**Consultation Response from KC,
Trees**

2024/91383 St Johns Church, Jackroyd Lane, Newsome, Huddersfield, HD4 6QU

Erection of extension and external alterations

Date Responded: 04/06/2024

Drawing
Proposed Site Layout
Scale @ A1
1:100

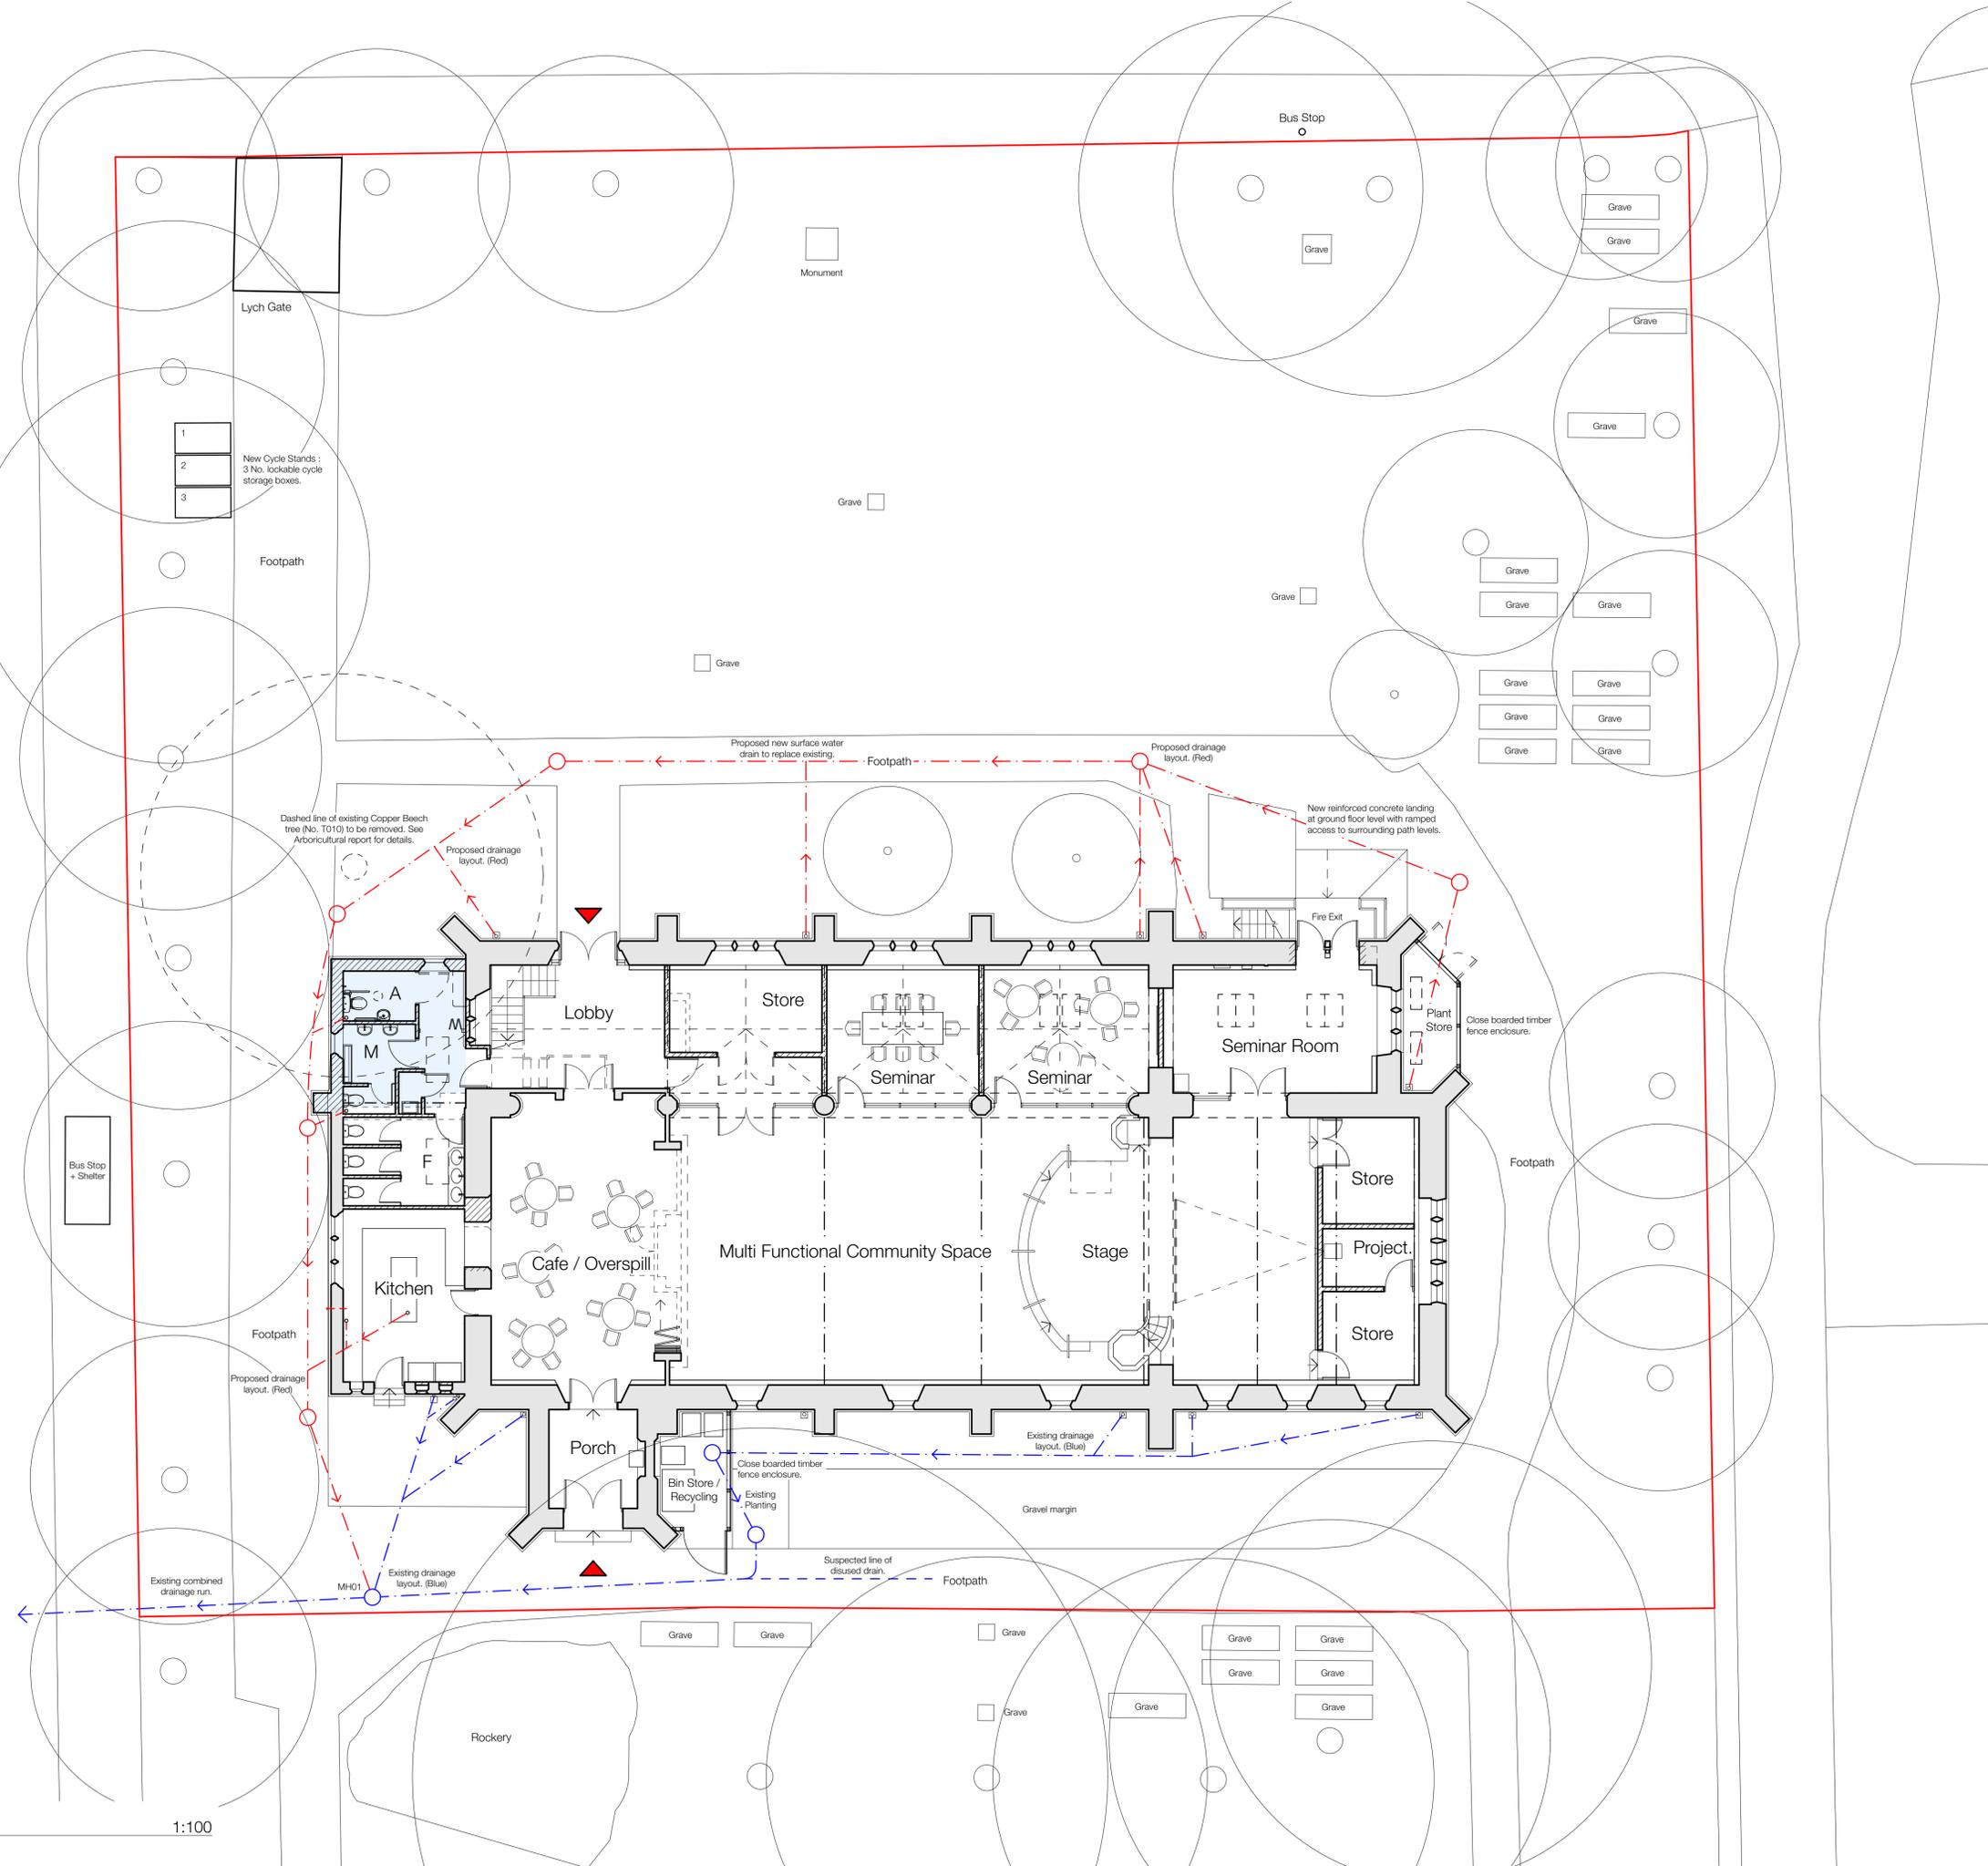
The existing site is surrounded by TPO'd trees however there should be little to no effect on these protected trees providing the foundation advised provided in the Arboricultural Impact assessment is followed. The tree labelled T10 which is suggested for removal to facilitate the extension is not protected and therefore is an acceptable loss.
